**Subject: Canal Landing New Yard – Phase I
40 West Commercial Street
Response to Site Plan Application Review Comments**

DEPT. OF PUBLIC SERVICES REVIEW COMMENTS DATED NOVEMBER 21, 2012

WOODARD & CURRAN REVIEW COMMENTS DATED NOVEMBER 27, 2012

PLANNING COMMENTS FROM BILL NEEDELMAN DATED NOVEMBER 27, 2012

DRAWN: CMW DATE: APR 2012  
 DESIGNED: RJW SCALE: 1" = 50'  
 CHECKED: SRB JOB NO. 3091  
 FILE NAME: 3091-SITE LAYOUT-ALT  
 SHEET **C-2.1**

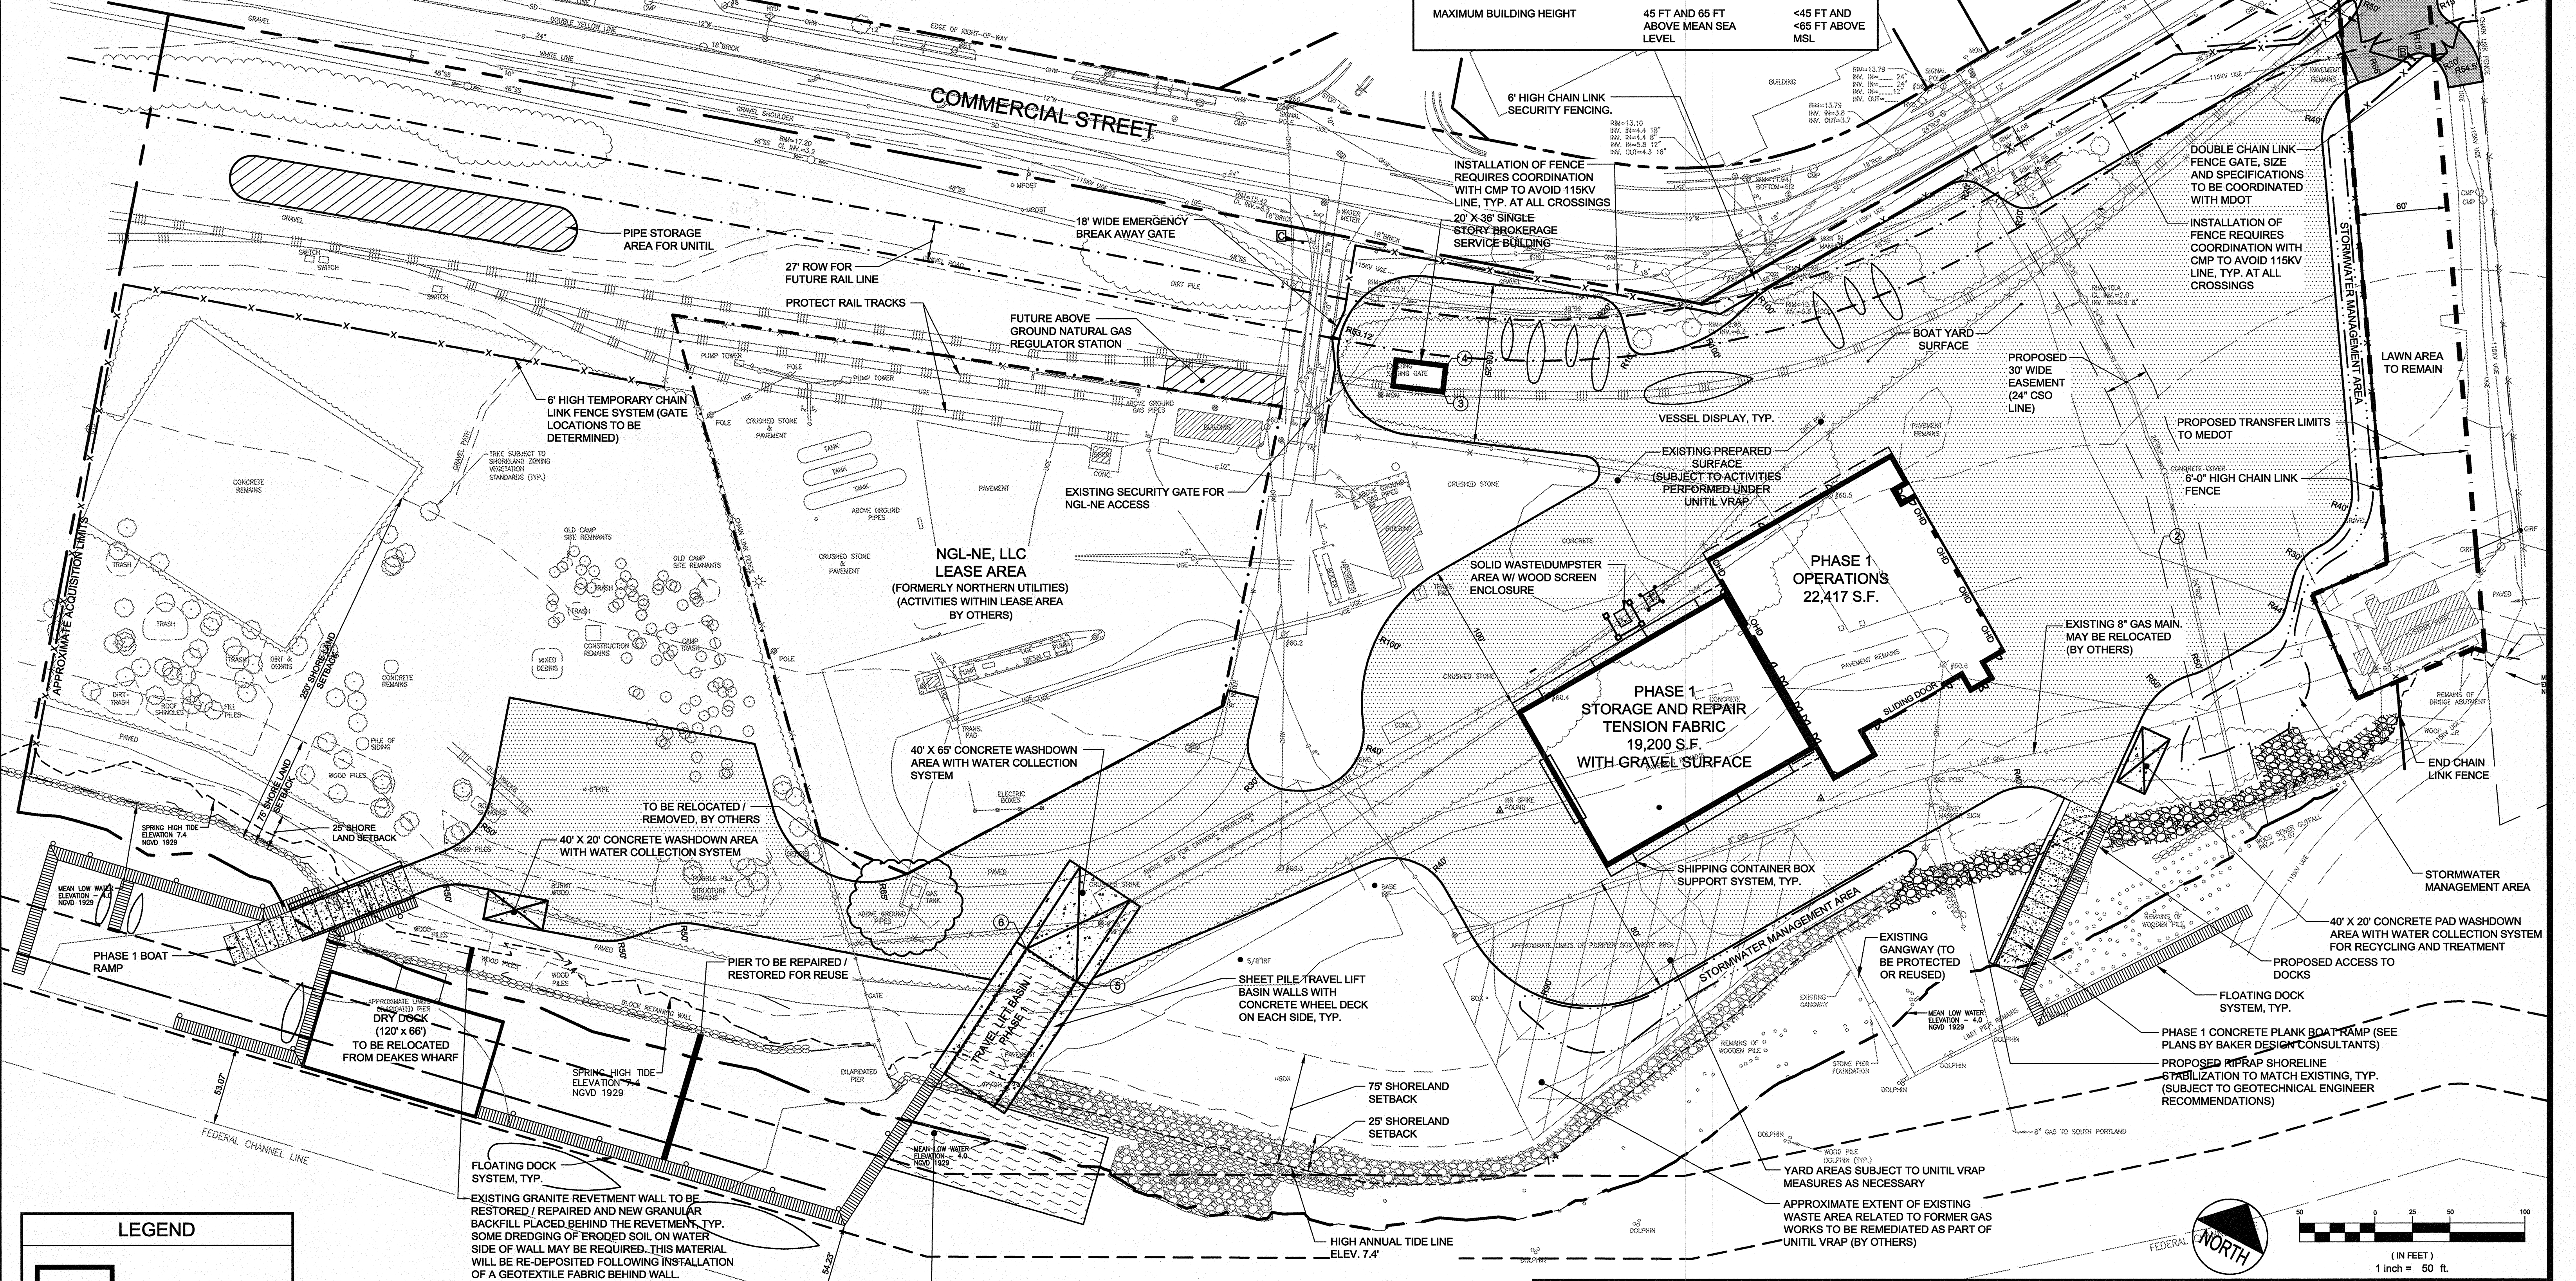
In support of the waiver request, the applicant is asked to describe how the basic pedestrian transportation access needs of the use are to be, or could be, addressed.

Removal of Rail Track: The applicant is asked to provide evidence that the tracks to be removed have either been officially abandoned or a legal opinion that abandonment is not needed. State and Federal process have been required prior to the removal of track from city-owned rail track.

The comment outlines the basic characteristics of the site's pedestrian access conditions. It is our opinion that pedestrian signage directing walkers towards the easterly project entrance may be beneficial. Currently, substantial paved conditions exist between the proposed existing easterly entrance and the IMT entrance that would allow relatively easy walking access to the existing crosswalk at the IMT. Based on the traffic volumes and roadway curve conditions at Nova Seafood directing pedestrian movements to the IMT crosswalk appears to be the safest alternative. Based on the proposed use as well as the incorporation of security fencing around the site perimeter, we foresee a very limited level of pedestrian access to/from the site, therefore the waiver request for sidewalk and curbing is reasonable in our opinion.

The amended site plans have been modified to include a 27' wide future rail line easement along the property frontage. This easement has been discussed with PanAm Railway officials and it will meet their needs in the near future if circumstances at the IMT warrant.

DeLUCA-HOFFMAN ASSOCIATES, INC.  
 778 MAIN STREET, SUITE 8  
 SOUTH PORTLAND, ME 04106  
 207.775.1121  
 WWW.DELUCAHOFFMAN.COM  
 DRAWN: CMW DATE: APR 2012  
 DESIGNED: RJW SCALE: 1" = 50'  
 CHECKED: SRB JOB NO. 3091  
 FILE NAME: 3091-GRADING-ALT  
 SHEET: C-3.1

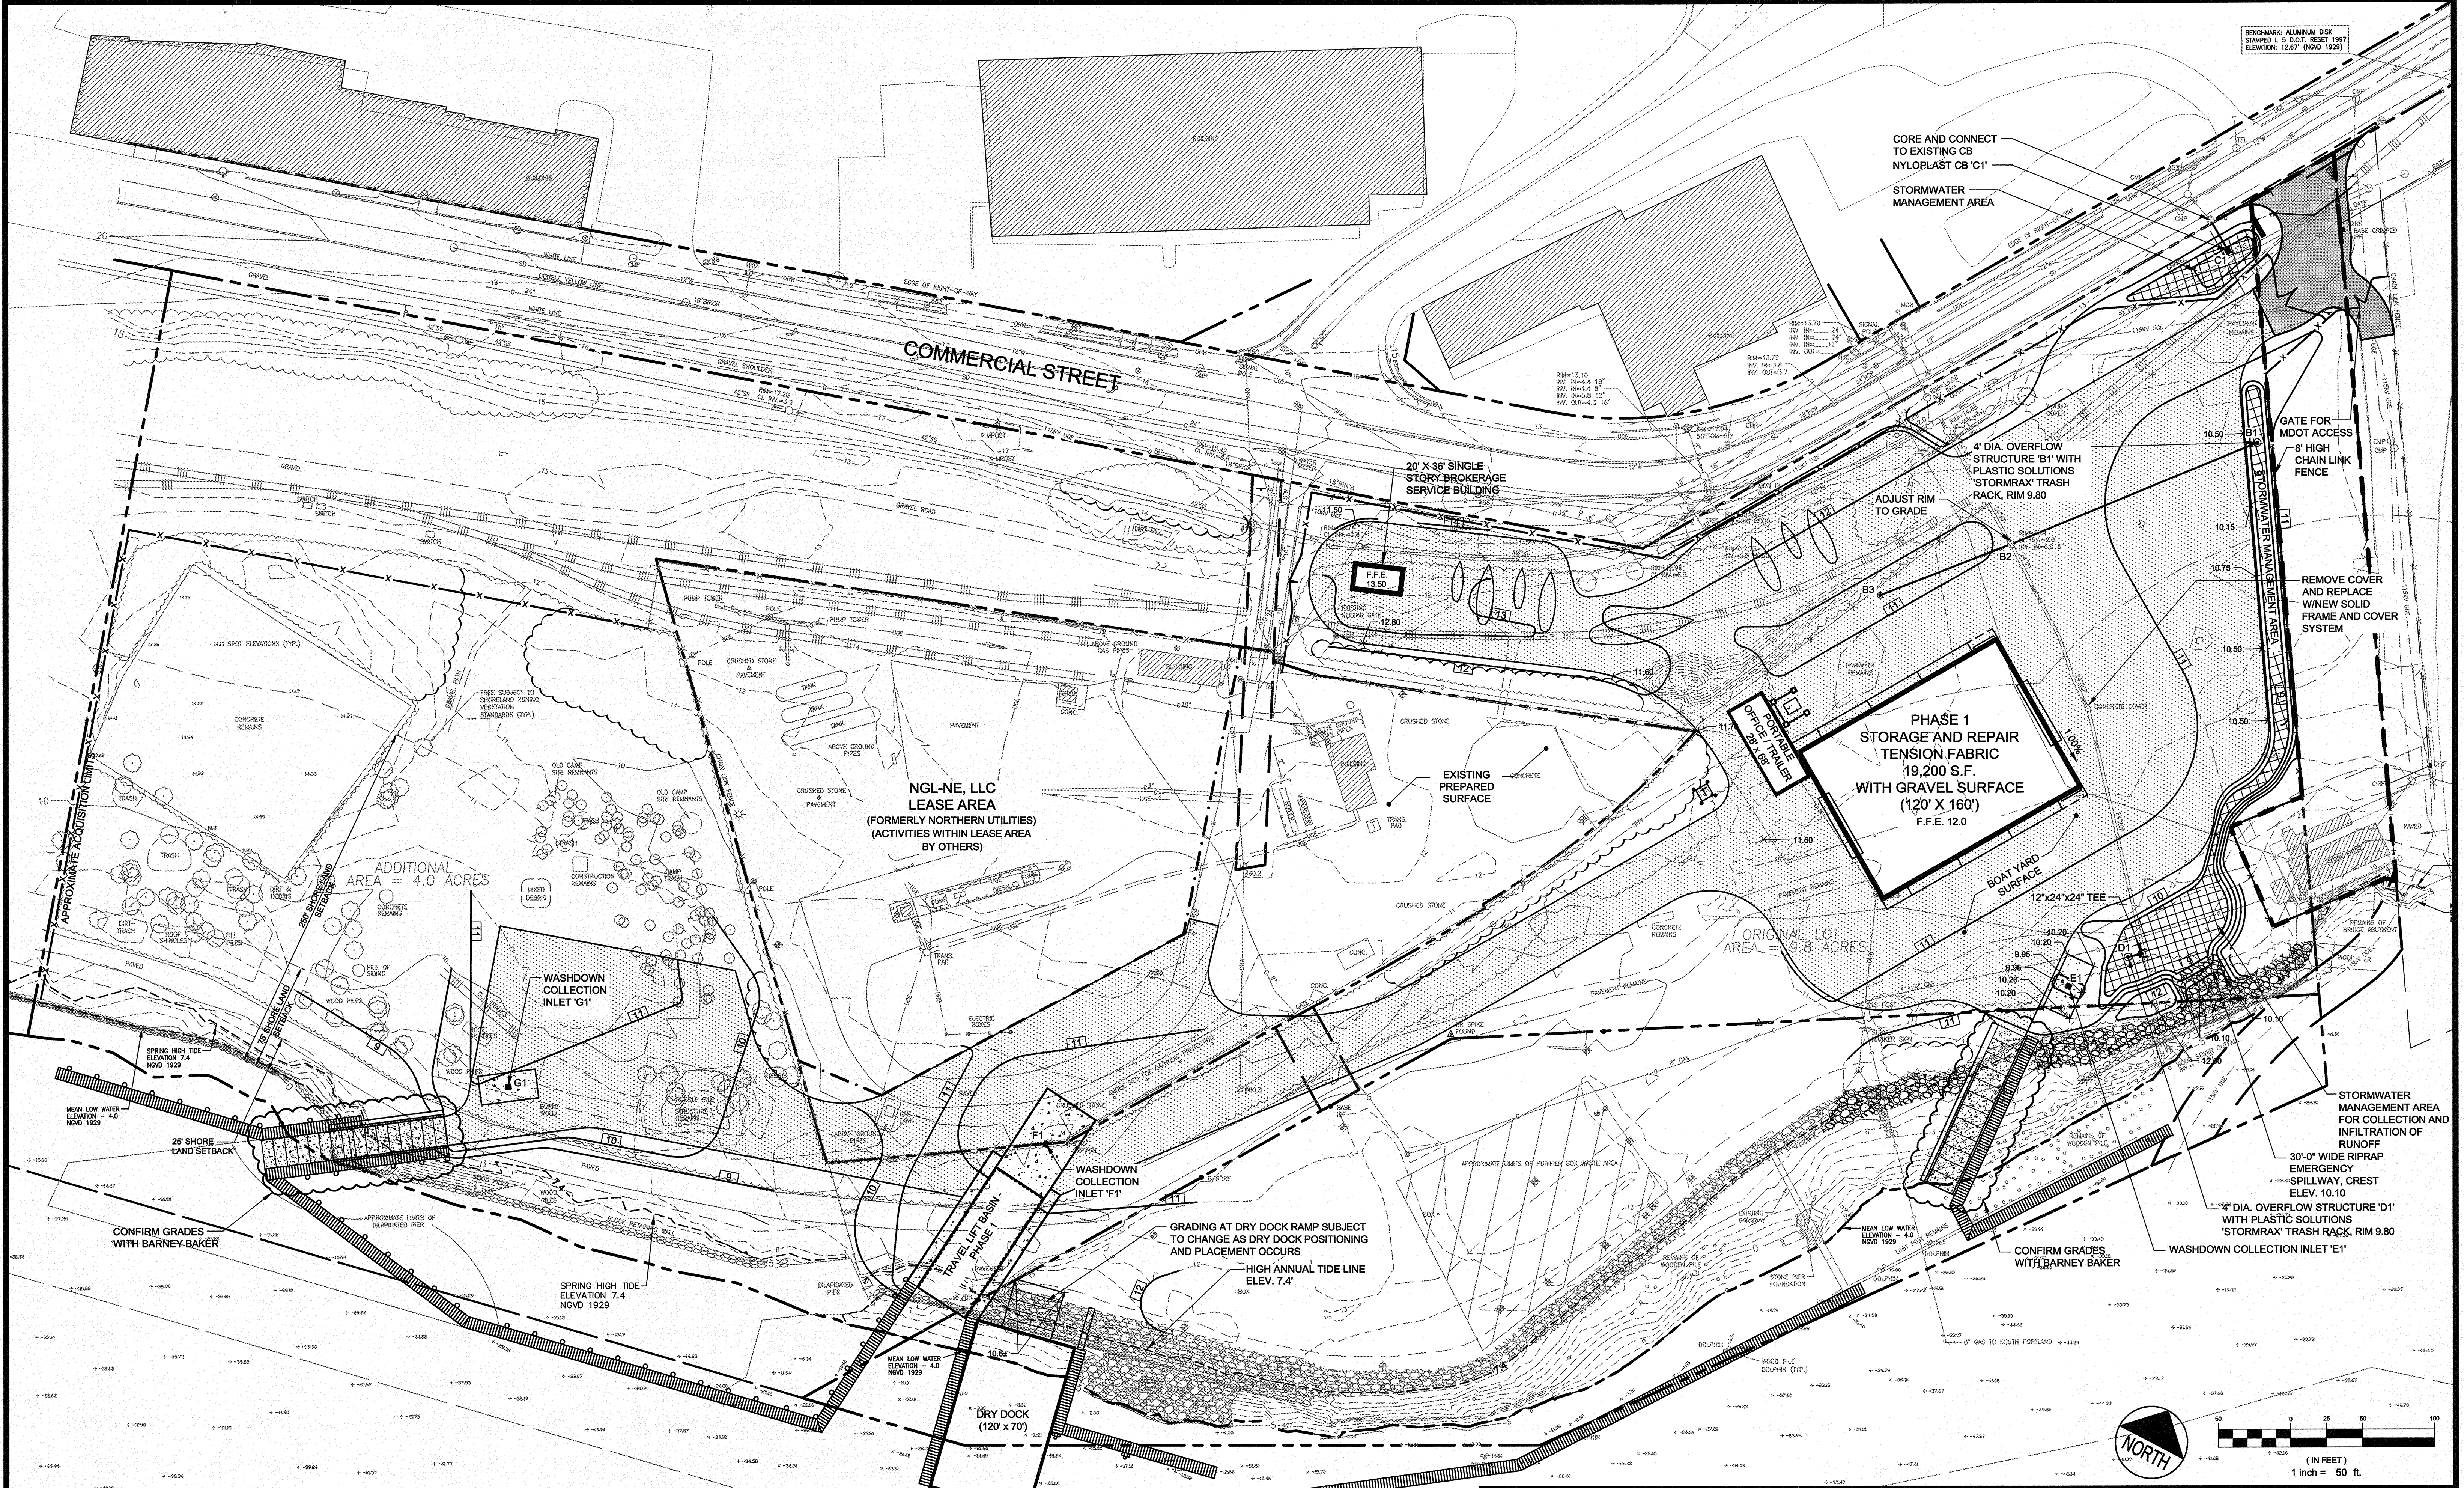
The proposed 12"x24"x24" tee connection from "Overflow Structure D1" to the 24" RCP sewer on Sheet C3.1 is not an acceptable means of connecting to the City's sewer/drain infrastructure. A connection of this size will require a manhole.

A new 5' diameter manhole has been added to the plan.

D VEGETATED DRAINAGE SWALE DETAIL

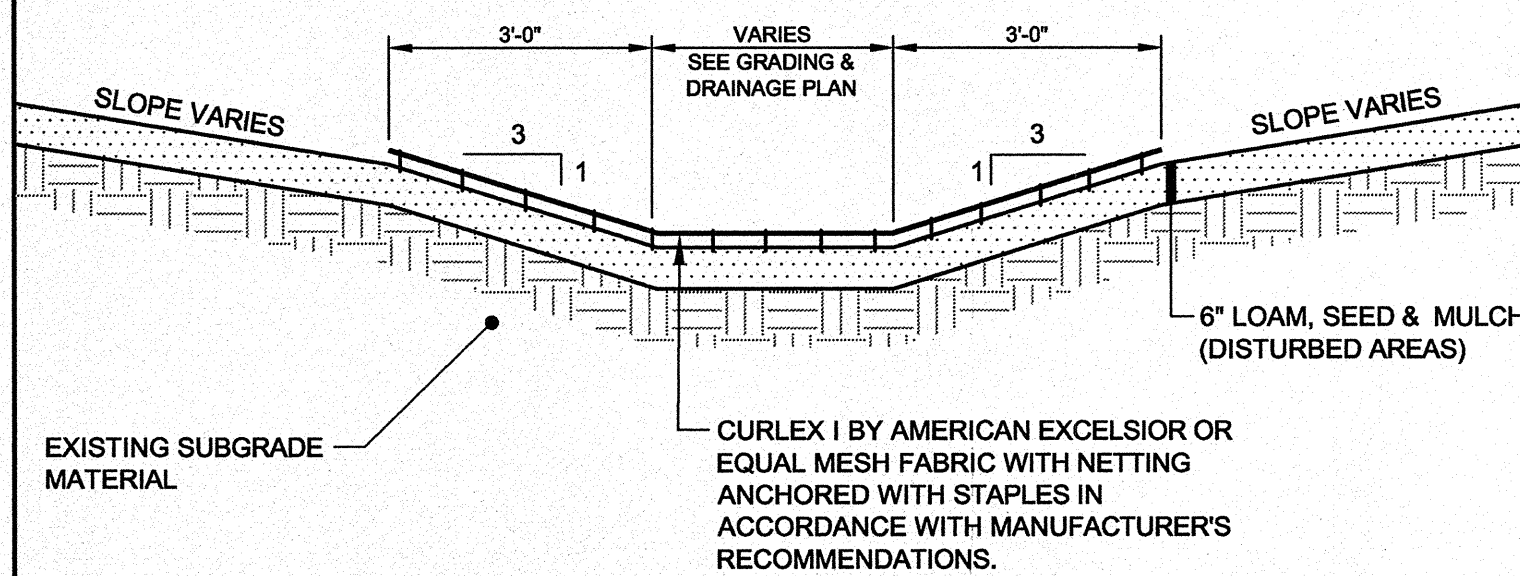
iv) Please provide additional details identifying surface preparation, materials of construction, and surface vegetation for the "Stormwater Management Areas" noted on C3.1.

The designated stormwater management areas are intended to be grassed swales that will be dry the majority of the time, but will collect and convey runoff during major storm events. A standard detail is included with the plans as Detail D on Sheet C-6.3.
